Subject: AL/81/17/HH

Re Planning Application A1/81/17/HH

I am writing to object to the above application for the erection of a single storey outbuilding at the property of Mildmay.

SITE LOCATION & BLOCK PLAN

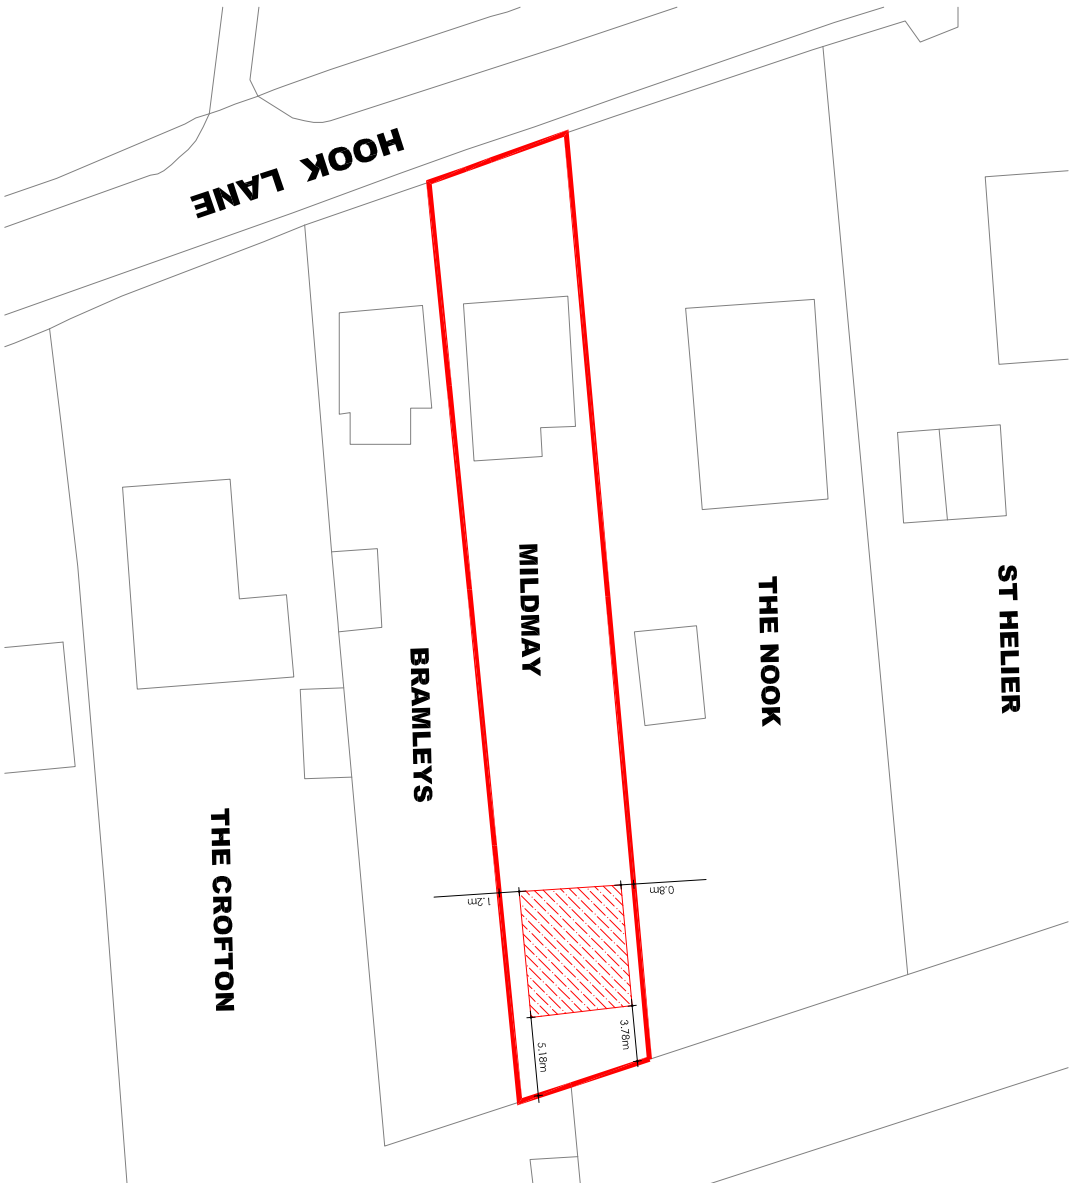
This proposed development takes up a significant area of a very small garden and its size is disproportionate to the space available. It represents a significant over development of the site. The proposed materials used in the development are not in keeping with other outbuildings in the area.

In this regard please see section EH5 of the Neighbourhood Plan. The loss of a substantial area of garden land to this development will increase the issues of standing water that are already suffered during periods of even modest rainfall and adversely affect the surrounding properties.

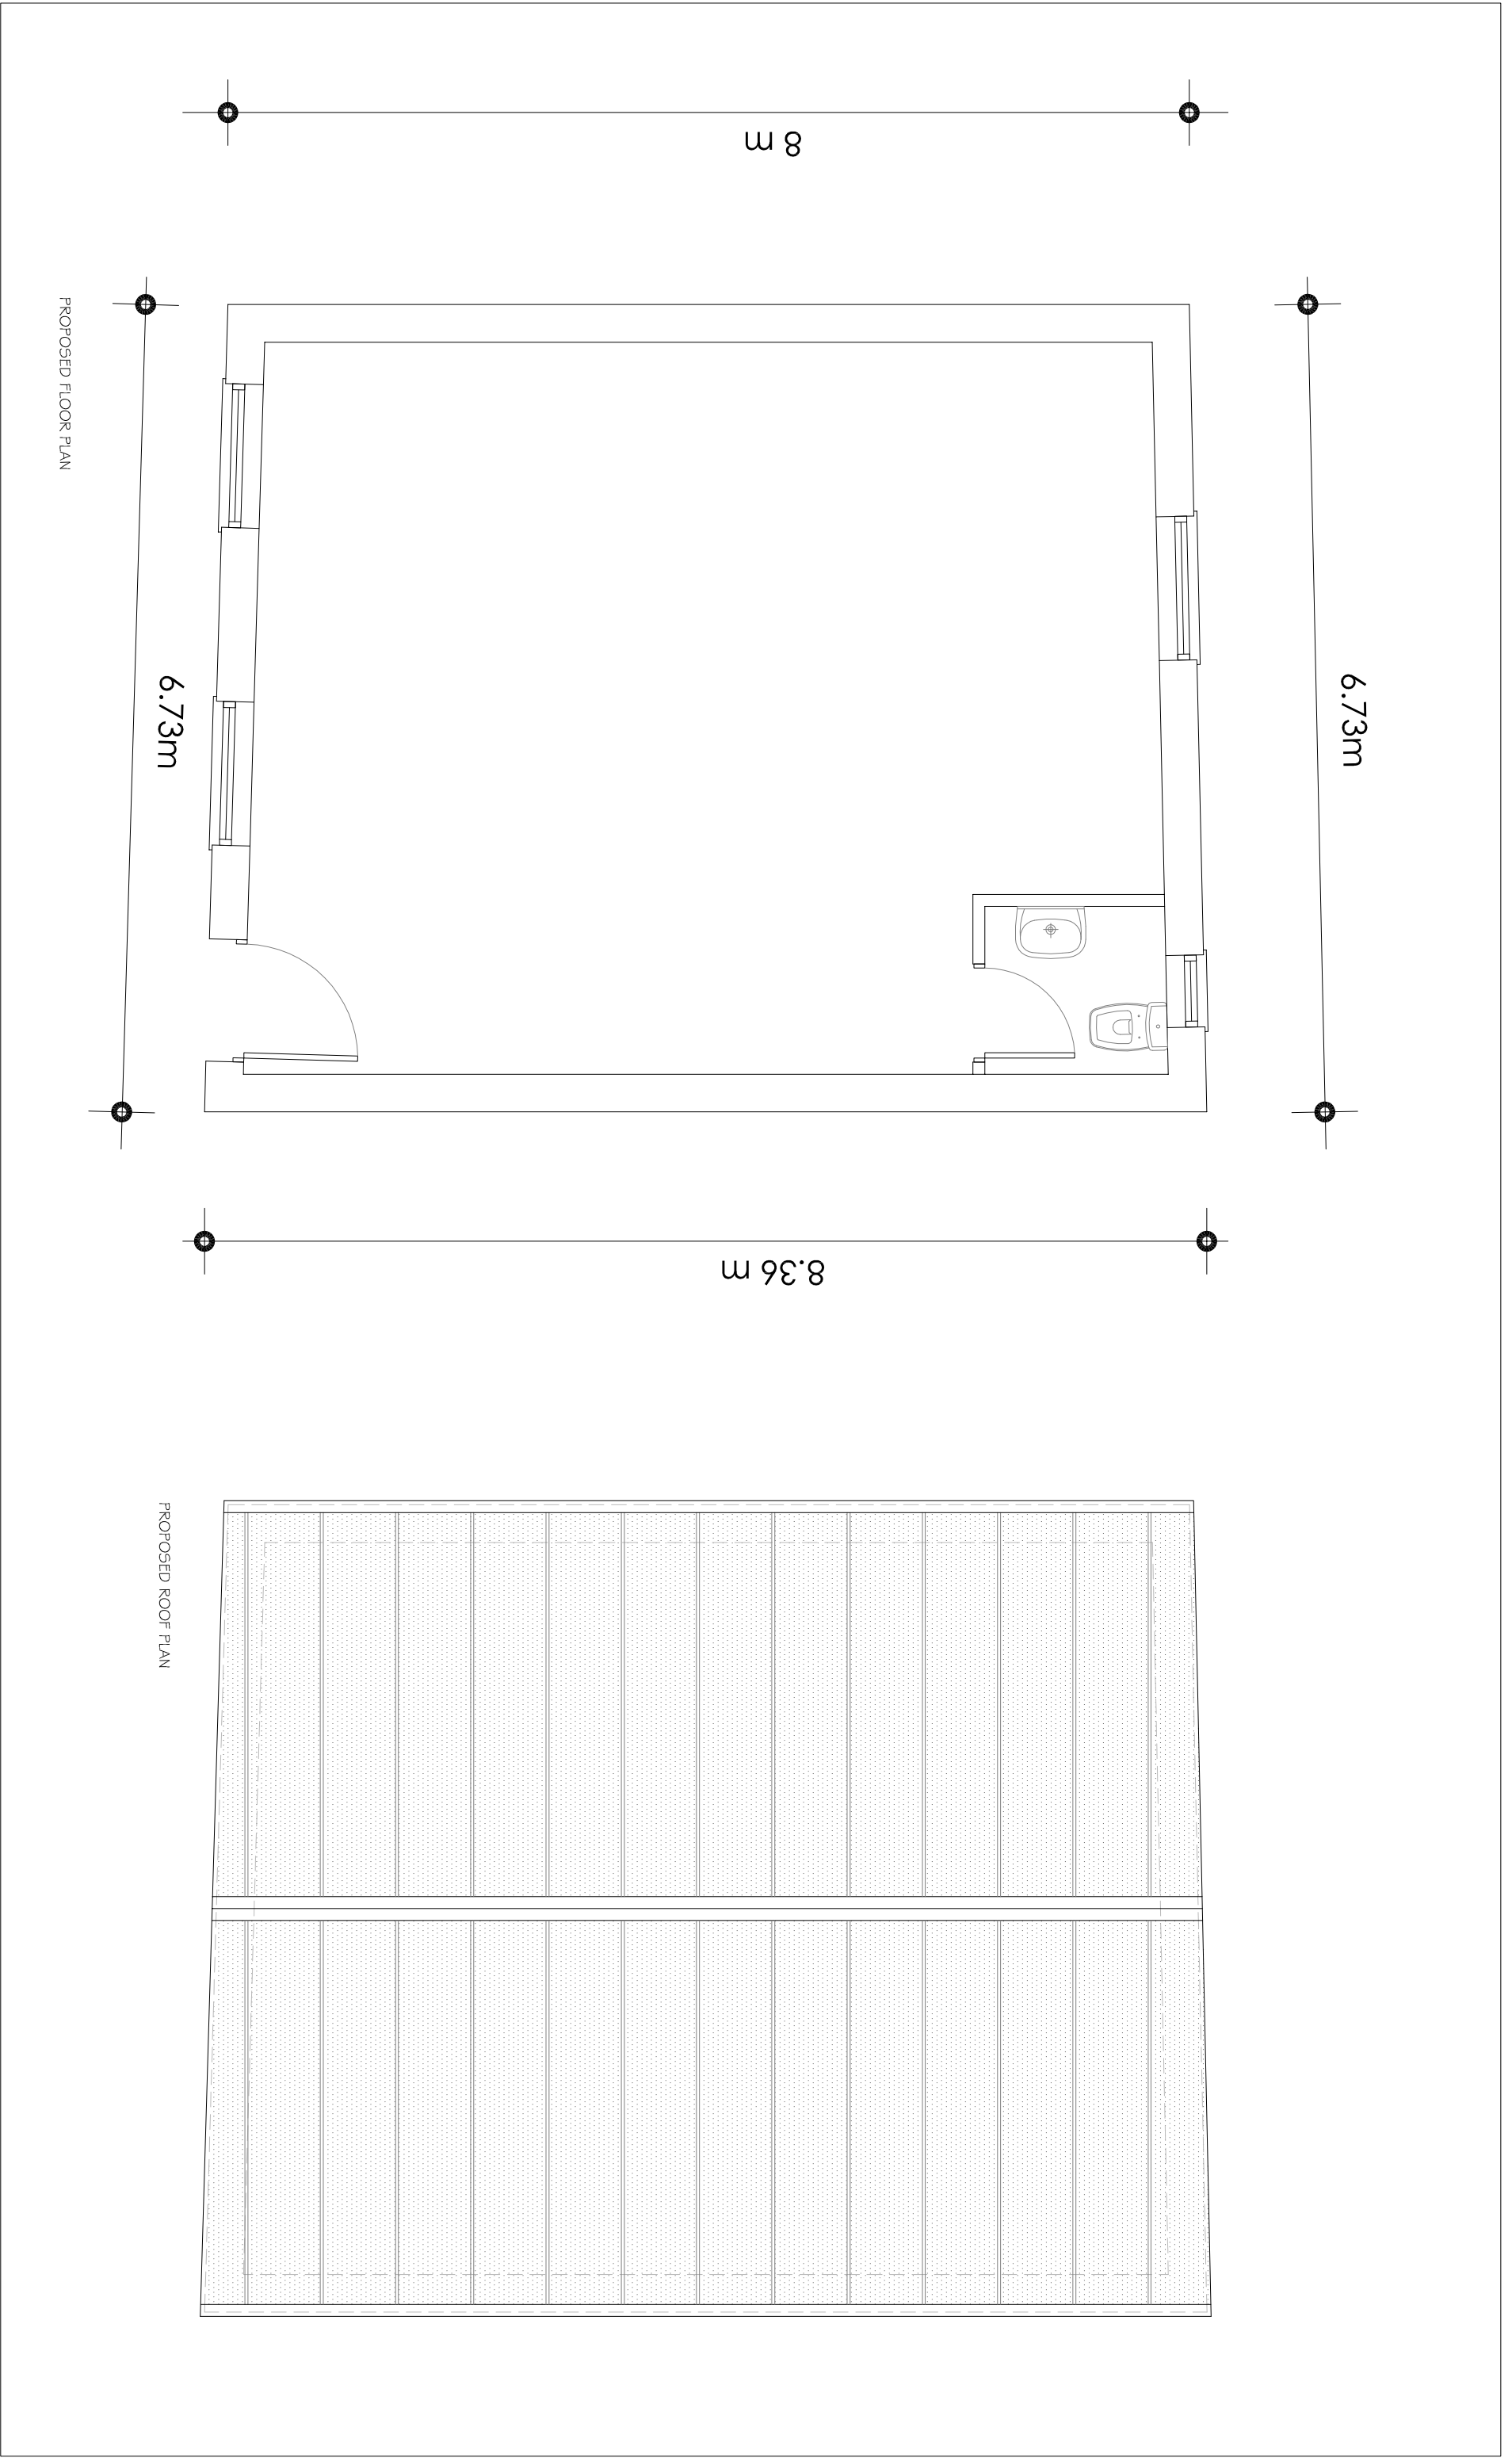
Neither the design nor the materials used are in keeping with the surrounding properties and the size of the shed represents a significant over development of a small rural site.
